The Coal
Authority

Re: Planning application 2024/60/92066/E

Outline application for erection of dwelling at Land adjacent 264 Barnsley Road, Flockton, Wakefield, WF4 4AJ

The Coal Authority response: FUNDAMENTAL CONCERN

title site plan  
number 24065D-01-P01  
scale 1:200  
size A2

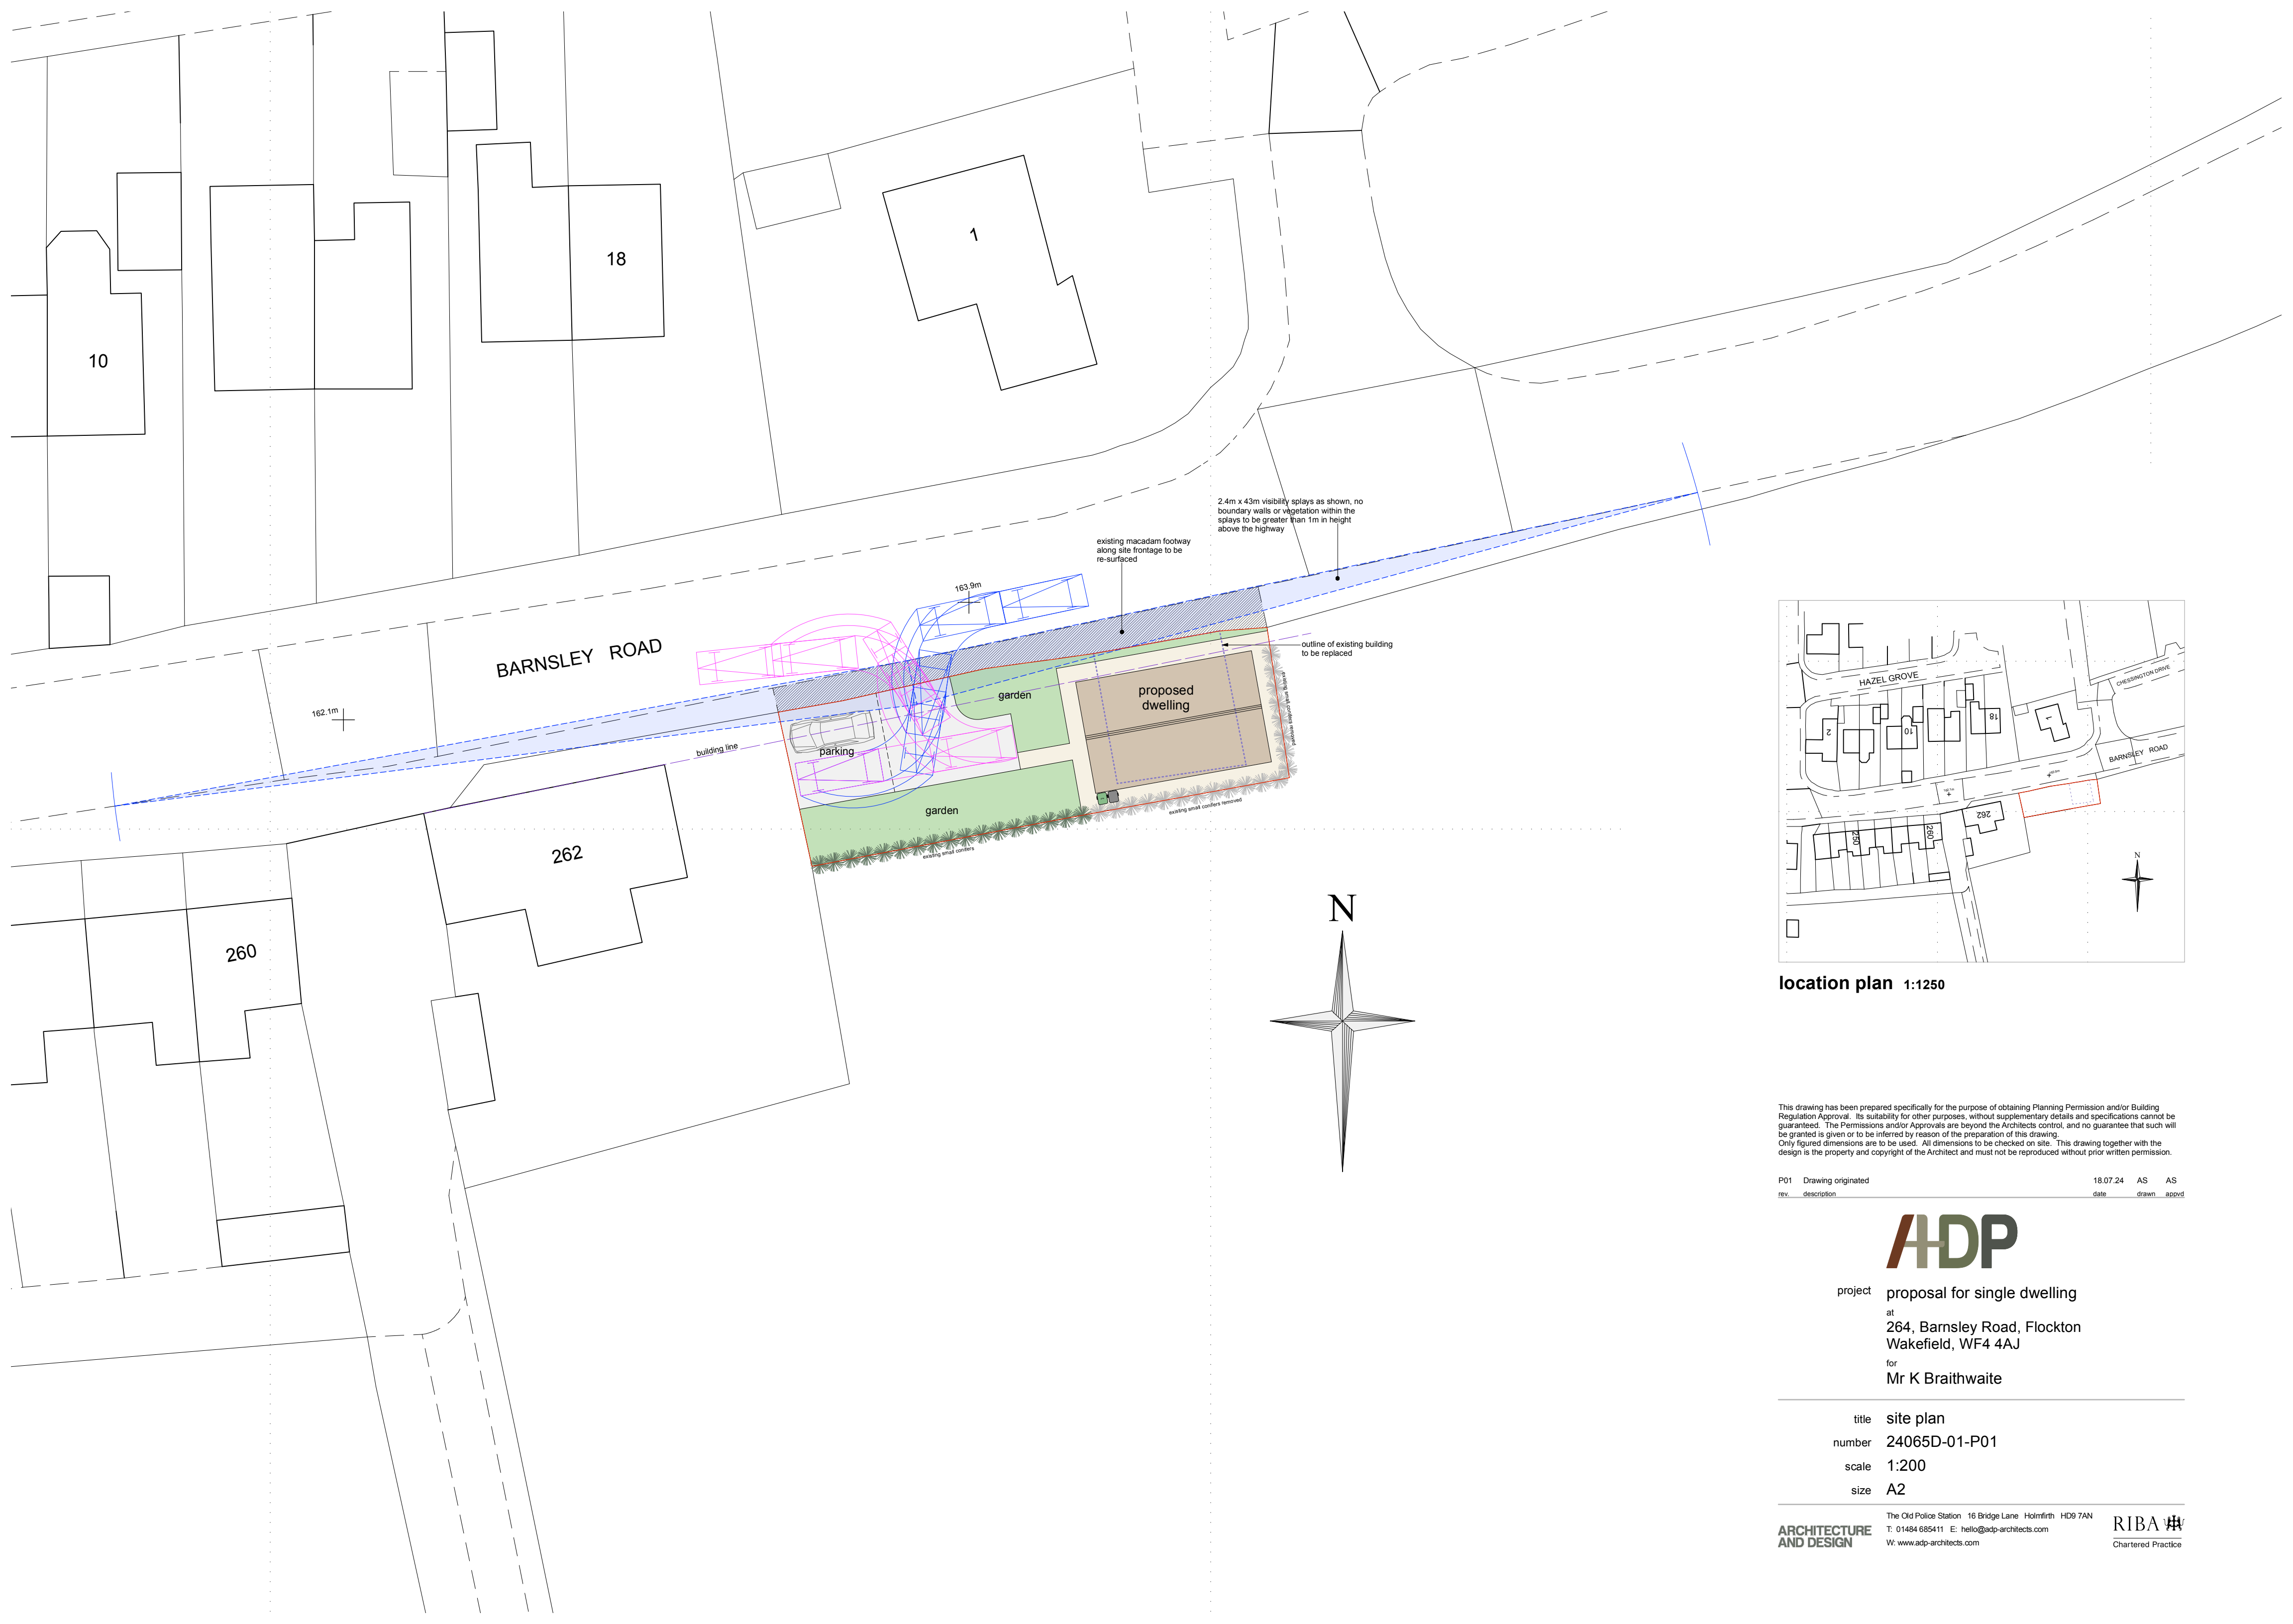
In addition, our records indicate that the potential zone of influence of an off-site mine entry (shaft, CA ref, 424415-023) encroaches marginally into the western part of the site. Due to potential plotting inaccuracies, the actual position of this former coal mining related feature could depart/deviate from its plotted position by several metres. Our information indicates that the shaft has been filled to an unknown specification in the past. An untreated or inadequately treated mine entry and its resultant zone of influence pose a significant risk not only to surface stability but also public safety.

Whilst the applicant is seeking outline permission for the erection of a dwelling on site, we note that they have submitted details of the layout of development for consideration by the LPA at this time. In light of the above policy, we are therefore pleased to note that the dwelling is proposed within the eastern half of the site, outside the potential zone of influence of the off-site shaft.

In accordance with the agreed risk-based approach to development management in the defined Development High Risk Areas, the applicant should be informed that they need to submit a Coal Mining Risk Assessment to support their planning application. As no relevant information has been submitted at this time, the Coal Authority's Planning & Development Team **OBJECTS** to this application.
